# **KIRKLEES METROPOLITAN COUNCIL INVESTMENT & REGENERATION SERVICE**

### **DELEGATED DECISION FOR DISCHARGE OF CONDITION A1 - NOTIFICATION OF A PROPOSED DEVELOPMENT UNDER LOCAL OR PRIVATE ACTS OR ORDER**

**Reference no.** 2026/CL/90302/W

| <b>Description</b> | Prior approval for alterations to<br>bridge MVL3/65, Lees Mill Lane,<br>west of Slaithwaite |

Drawing Title
**Prior Approval -
MVL3/65 Lees Mill Lane -
Existing and Proposed
Elevation and Section**

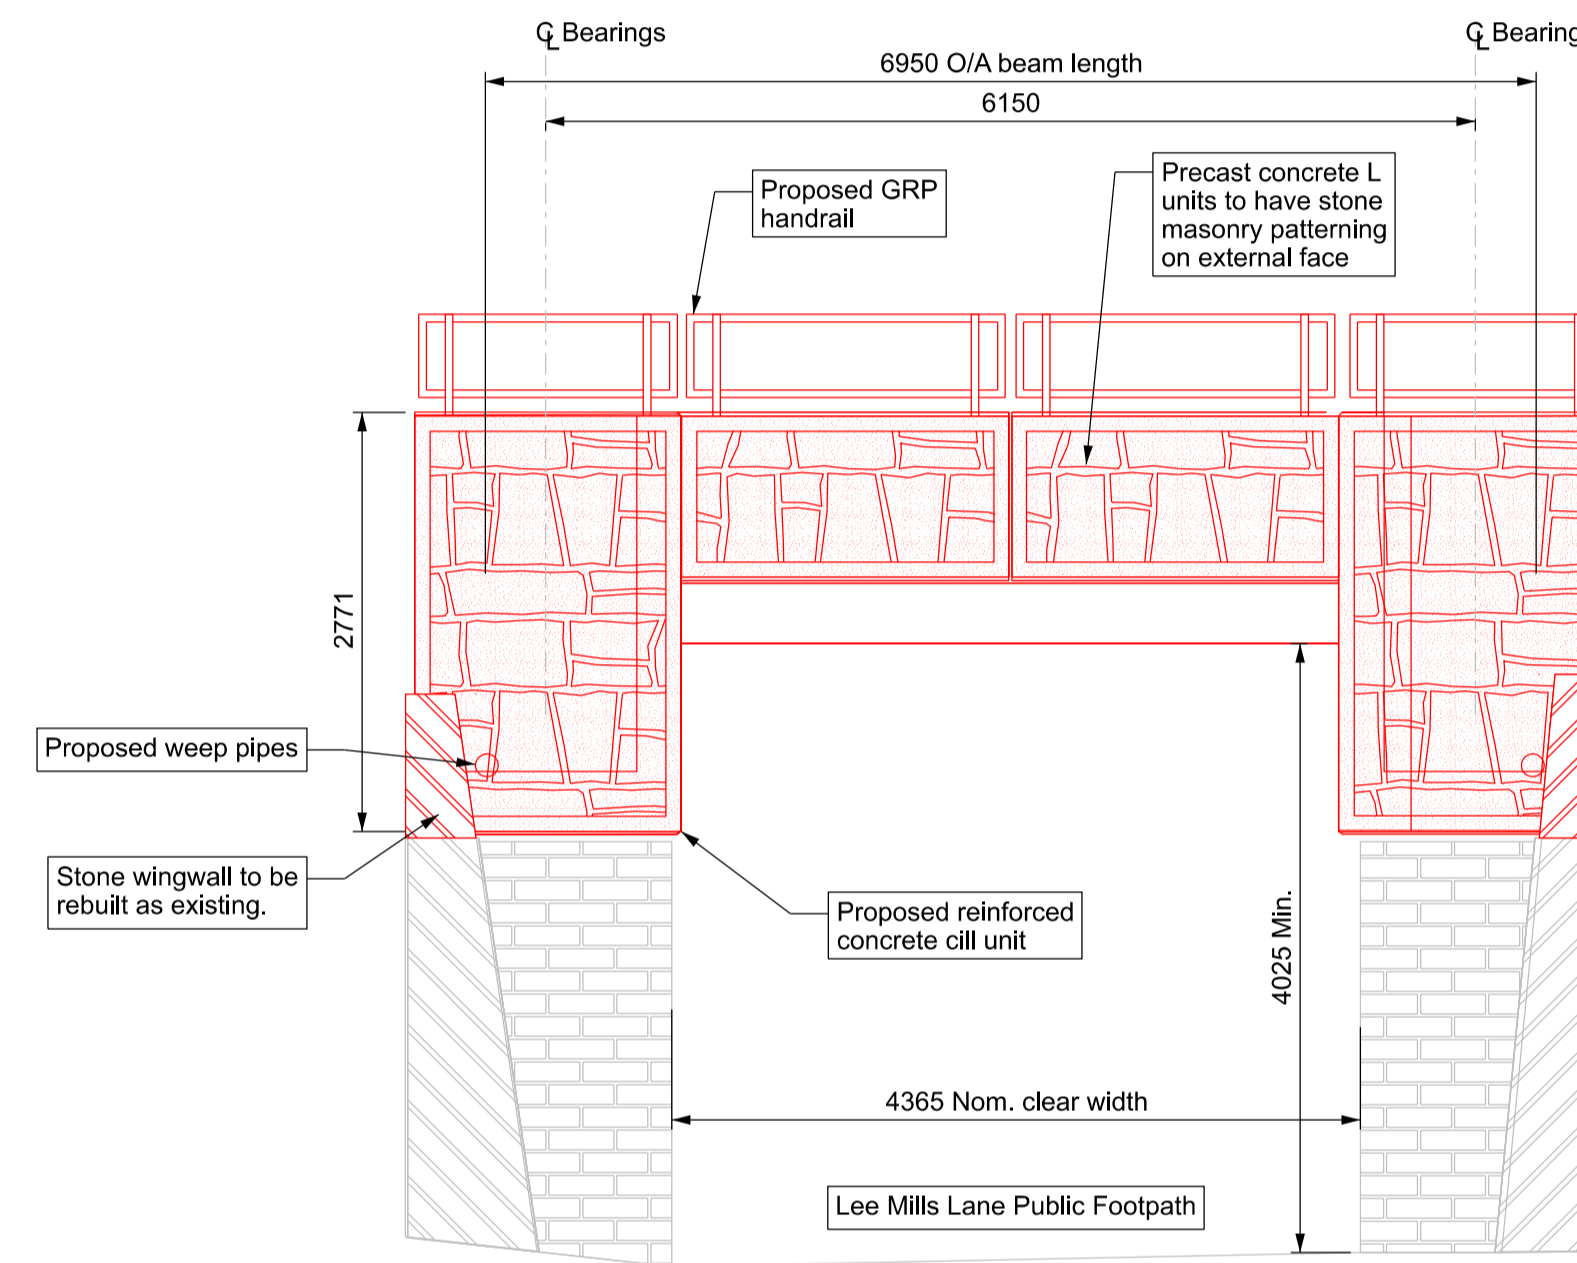
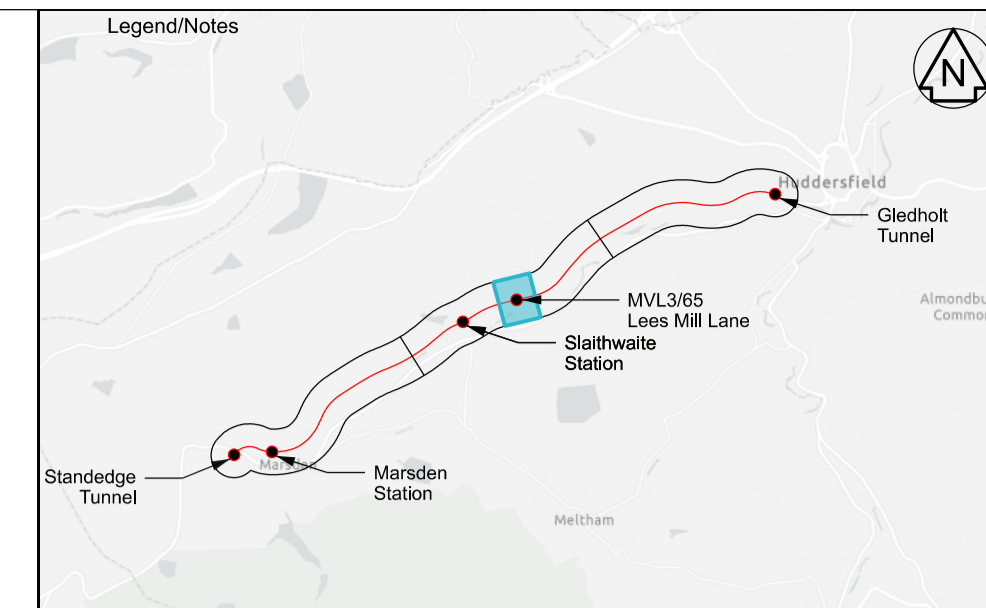
- *The pre-cast concrete L-units shall be finished with natural stone cladding design pattern to match the natural coursed stones below. The concrete shall match the existing natural stones by colour, texture and coursing.*
- *The GRP handrail shall be finished in a black or green colour*

In respect of other matters, it is proposed the soffit height and minimum clearance of the existing bridge would be reduced on the new structure over the public highway

(from 4.215m Min 5.15m Max to a minimum height of 4.025m). As Highway Safety is not a material planning consideration under this application, a note is added to alert the applicant to contact The Local Highways Authority to ensure that all Highways legislation and guidance relating to the reduction in height of the structure is met prior to the commencement of the works.

1. Notwithstanding the submitted plans, a sample of the parapet finish[es] shall be submitted to and approved by the Local Planning Authority, prior to their installation. The external treatment of the parapet finish[es] shall reflect the retained stonework of the bridge in terms of colour, texture, finish and coursing. Thereafter the development shall be implemented in accordance with the approved details.

2. The GRP handrail, as shown on plans ref. 167037-TGP-54-MVL3-DRG-T-LP-165600 rev. P02 and 167037-TGP-54-MVL3-DRG-T-LP-167601 rev. P02, shall be finished in a black or green powder coating
